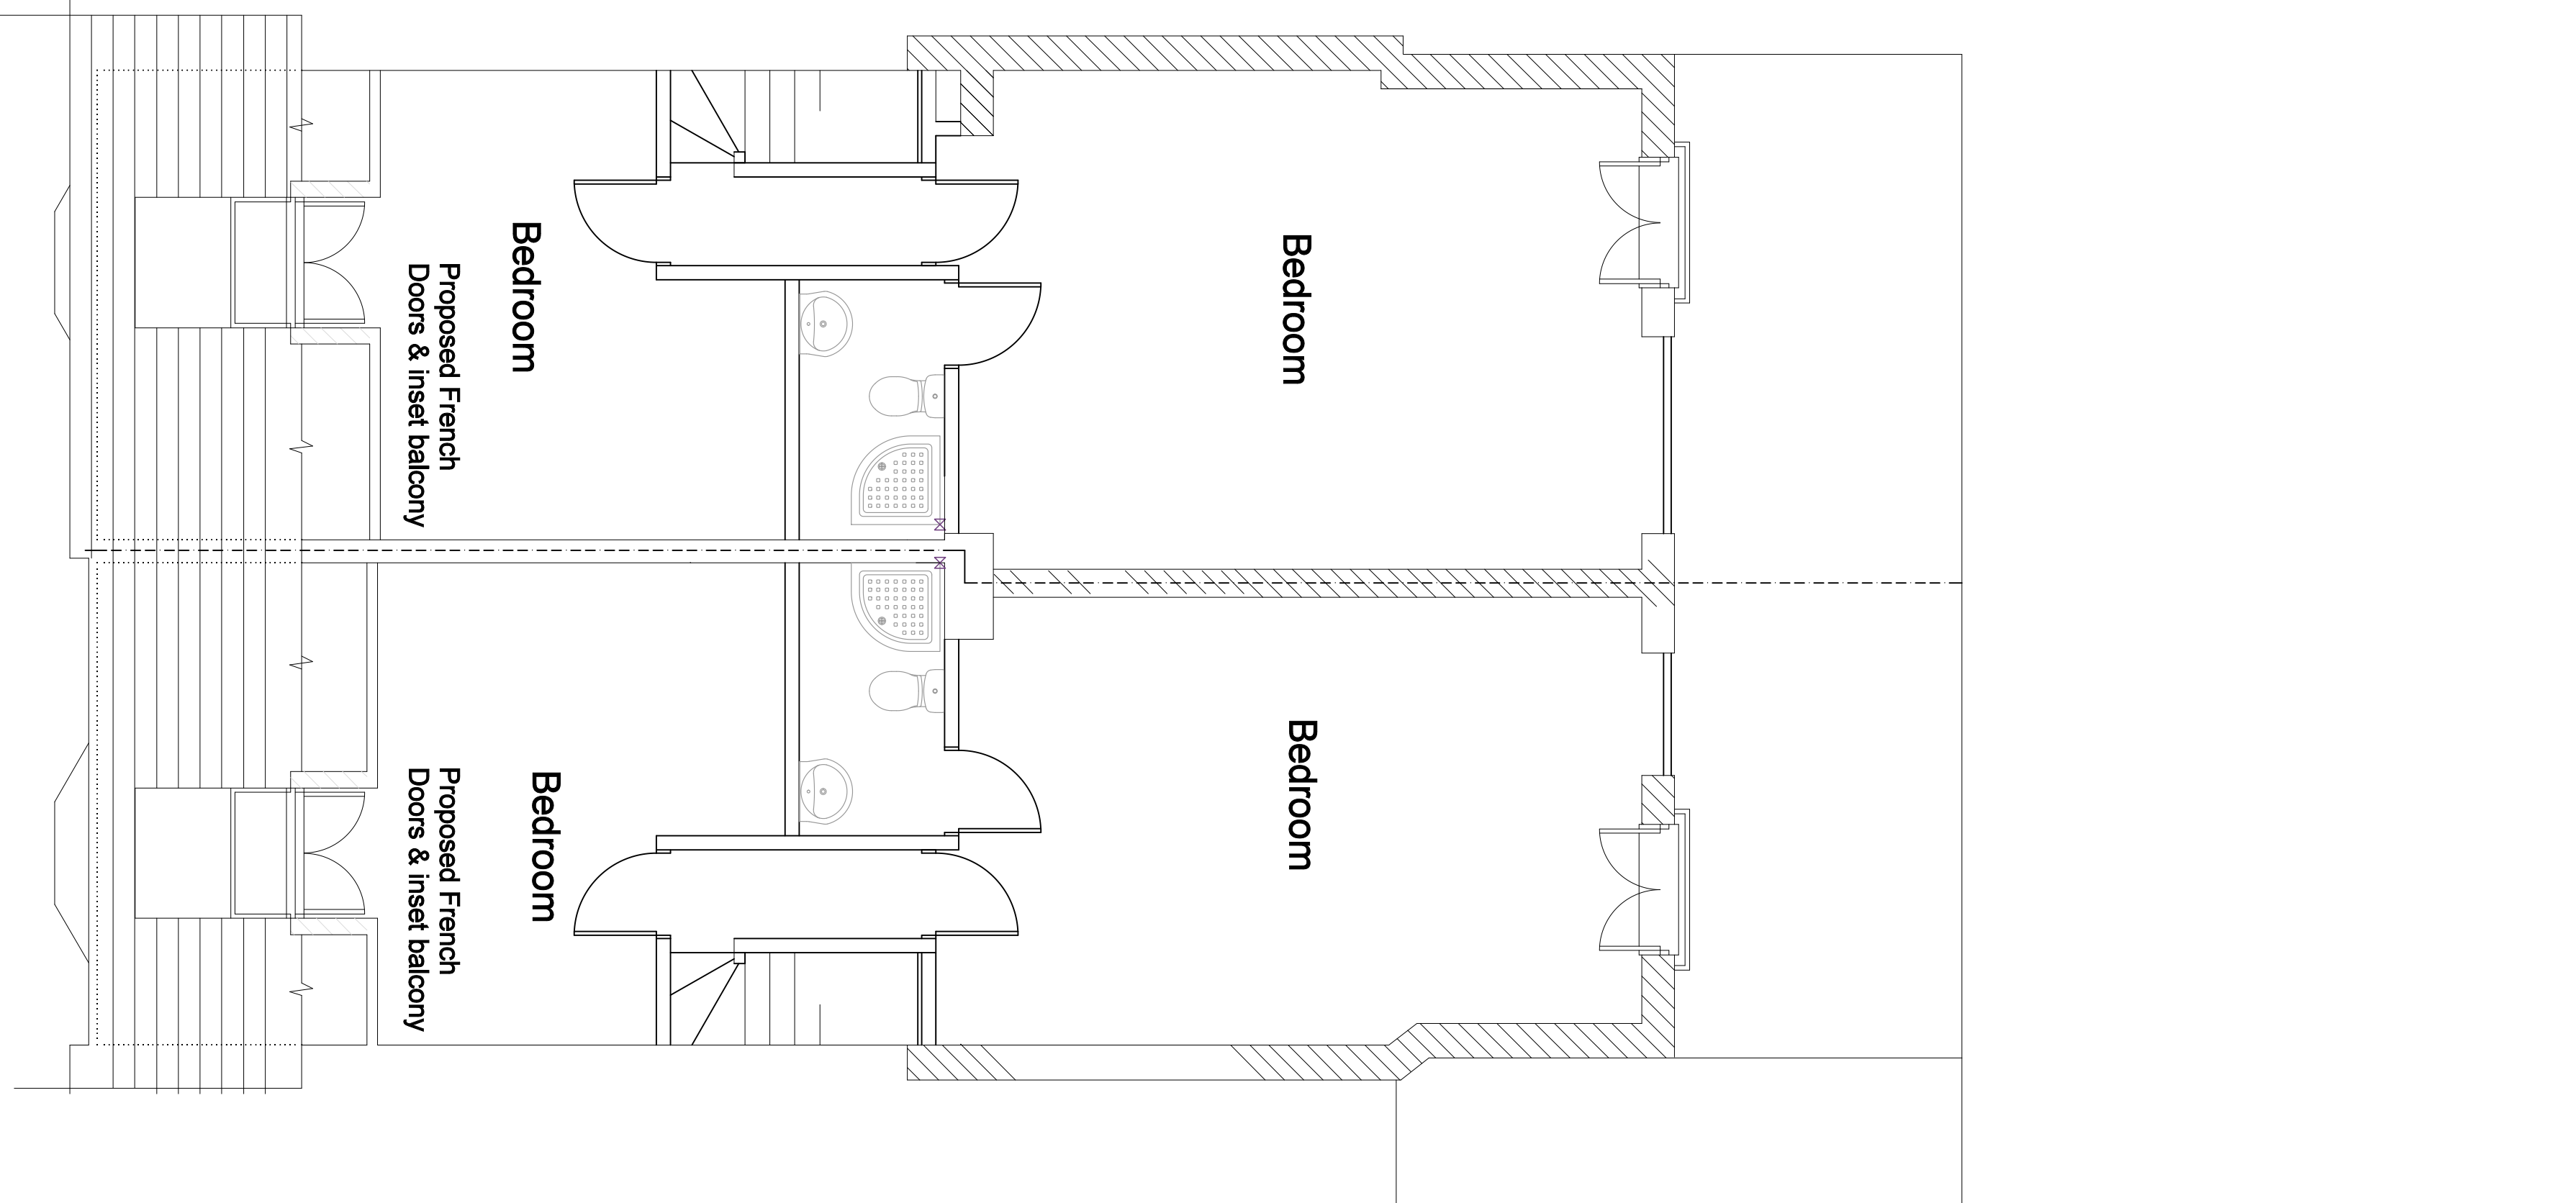
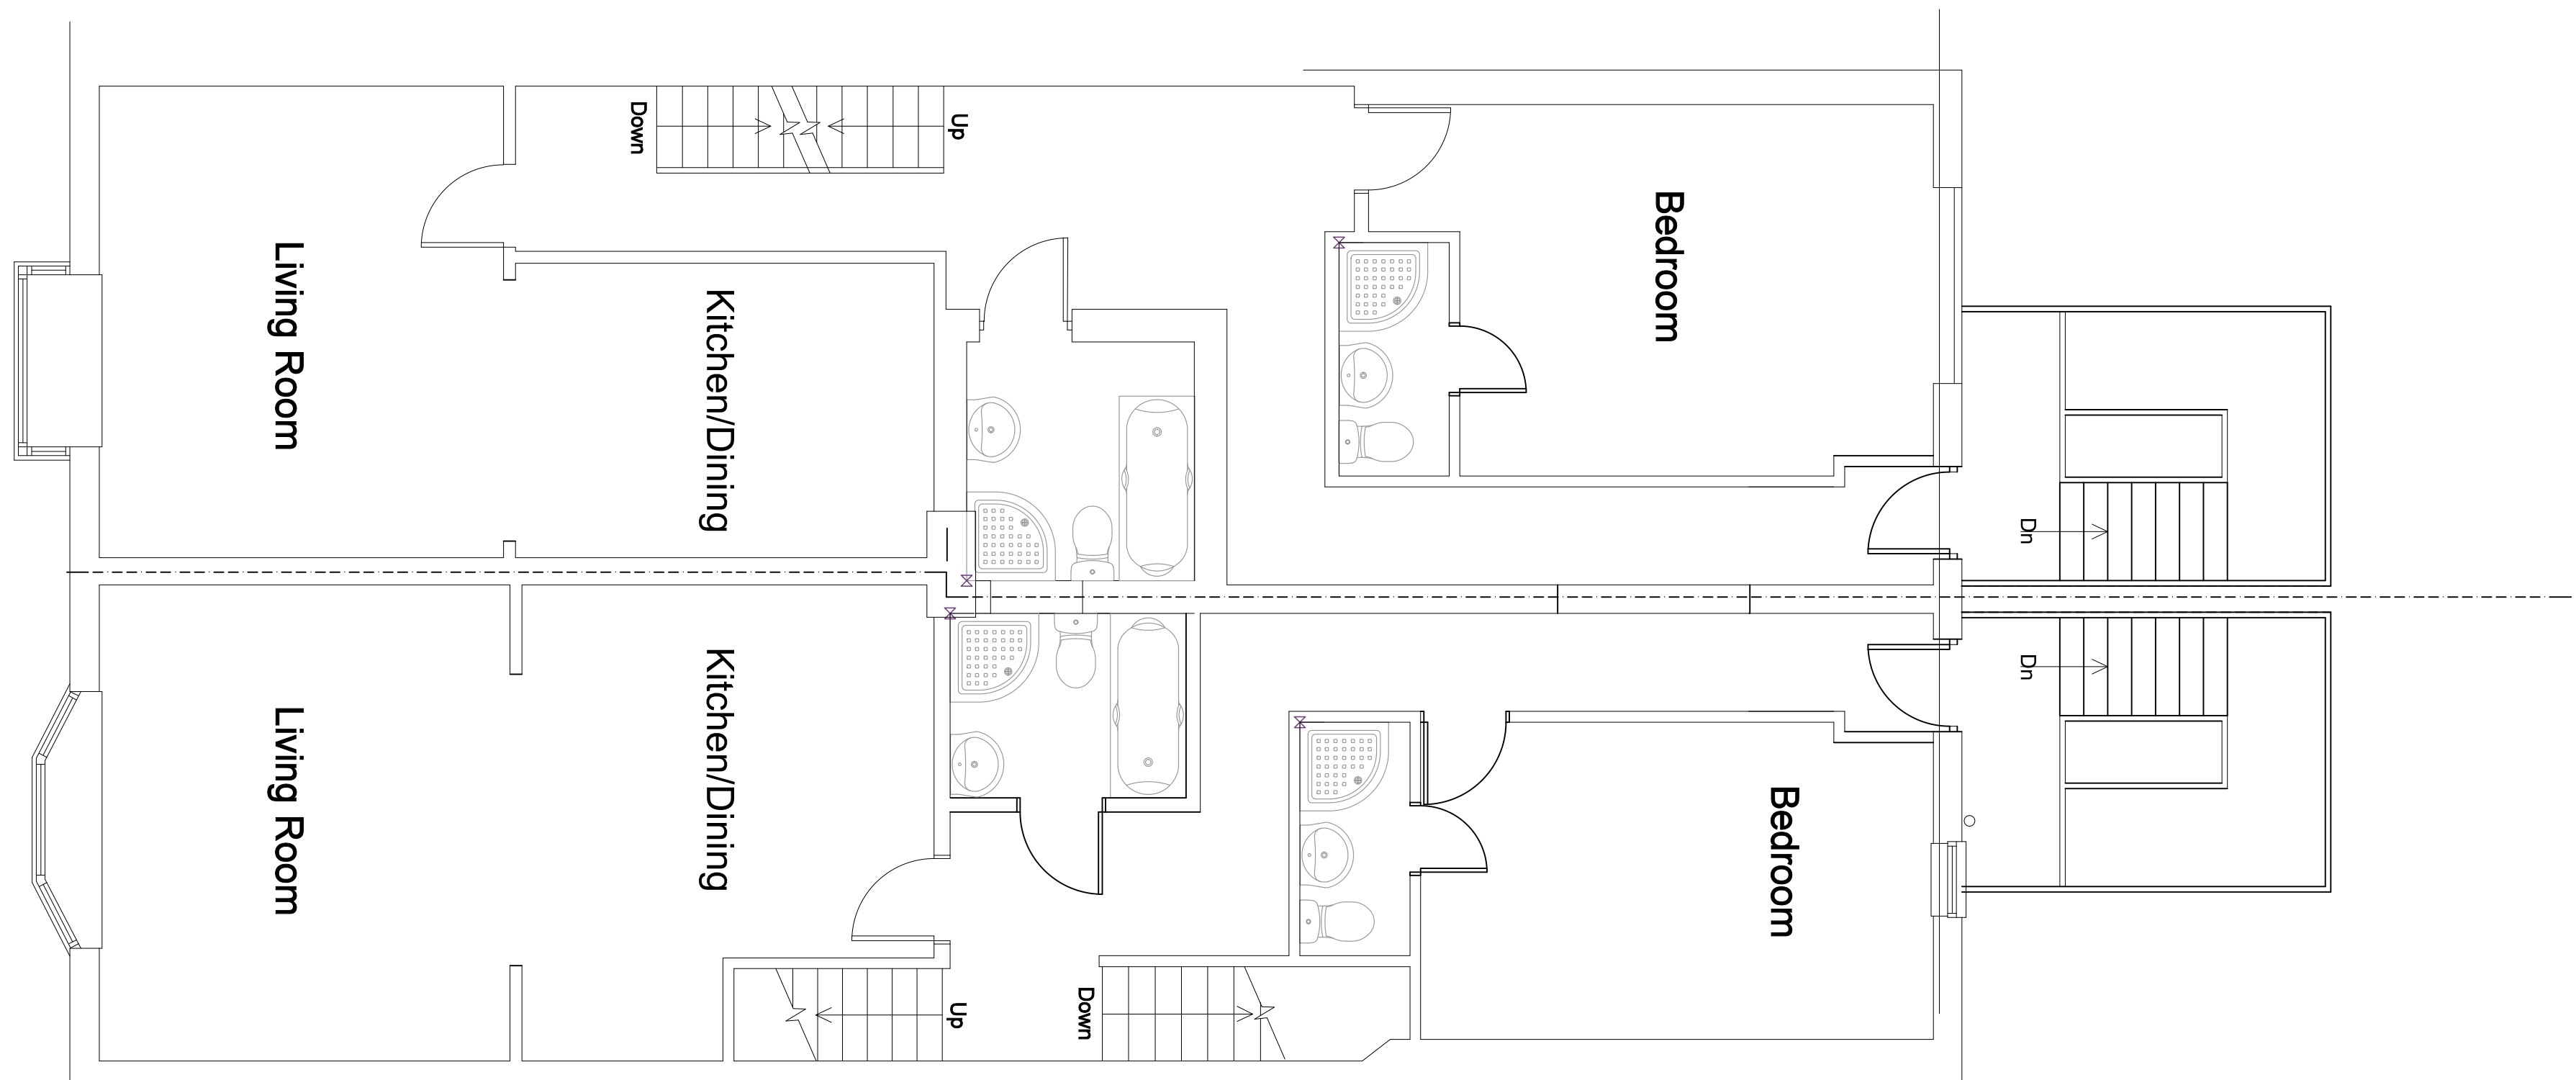
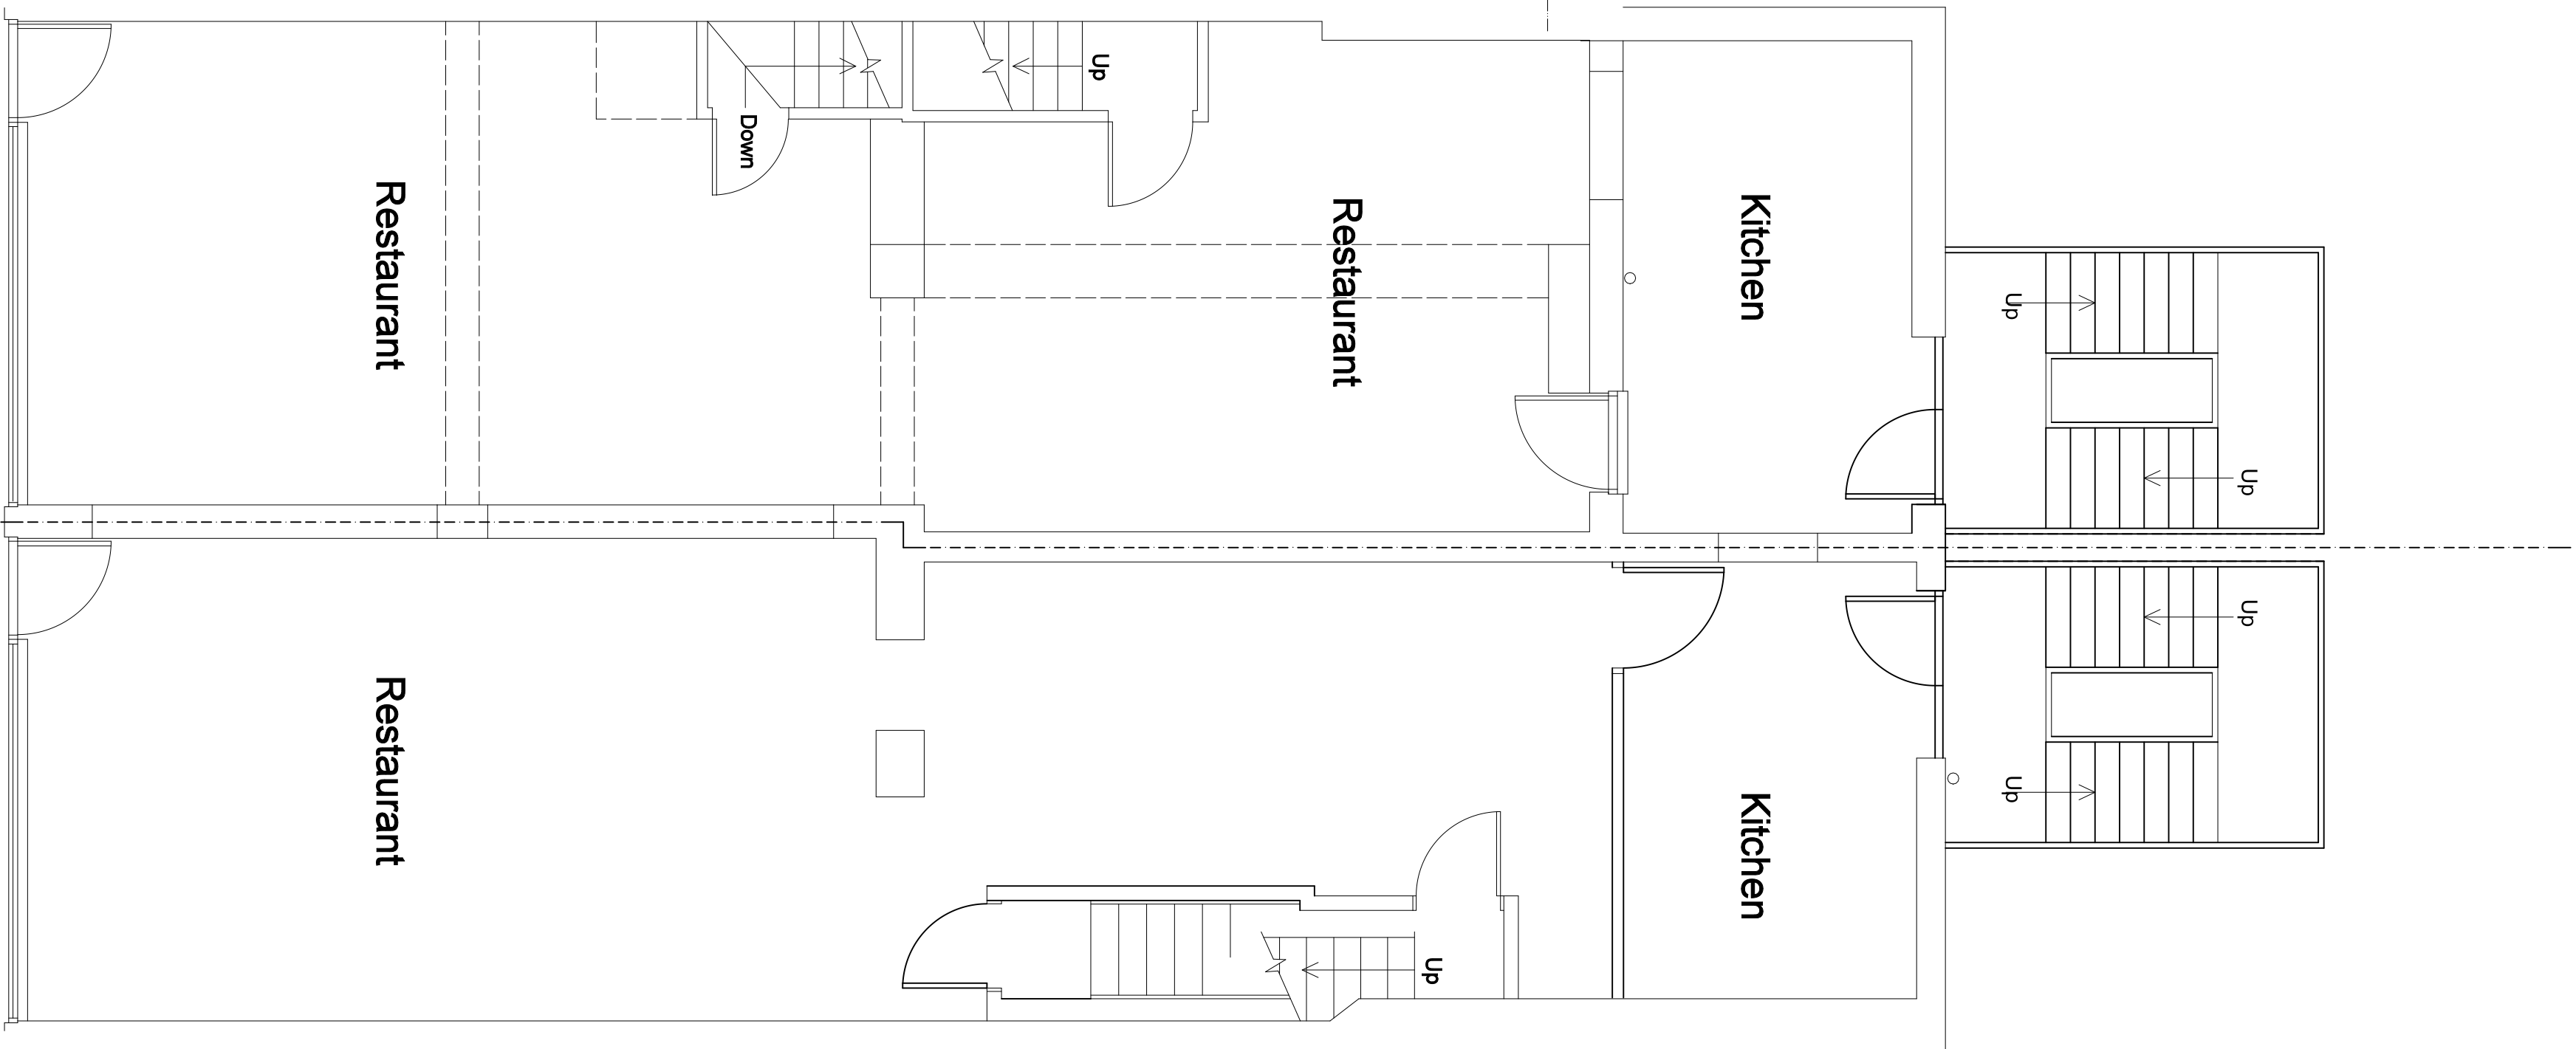
‘Regarding the ground floor retail premises proposals, it was observed that alterations to the Pier Road frontage would see the floor level raised by 50cm. The Plans however lacked clarity regarding this change or any detail on

provisions that would allow accessibility for those with impaired mobility. Similarly, there appeared to be no disabled toilet provision. Members considered the lack of these facilities went against the Arun's Local Plan strategic objectives for design (Section 13) and the emerging Design Guide which sought to promote development providing "opportunities for ease of movement for pedestrians" and buildings that were of a "good design which will contribute positively to making places better for people".

Lack of access and provision for disabled customers would be contrary to policy D DM1(5) and in its current form the application may well be recommended for refusal on this basis. I would therefore appreciate your comments/clarification, within the next 10 days, in response to the issues raised.

I attach elevations with pavement level marked at the same level as door threshold-it is now not the intention to raise the floor level as was proposed in the previous planning application LU/414/17/PL.

As regards the provision of toilets for disabled customers, I would point out that the River Breeze restaurant has operated with toilets on the lower ground floor for many years, and as the total seating for the two restaurants will be less than for the existing restaurant, it is felt that there is no worsening of a situation which it is conceded, is not ideal.

The problem faced by the client is simply that the installation of toilets fully compliant with Part M of the Building Regulations, with ventilated lobbies, at the same level as the restaurant seating, would take up so much floor space as to make the proposals unviable. As the retention of retail units is being encouraged, it is hoped that the Council will be sympathetic.
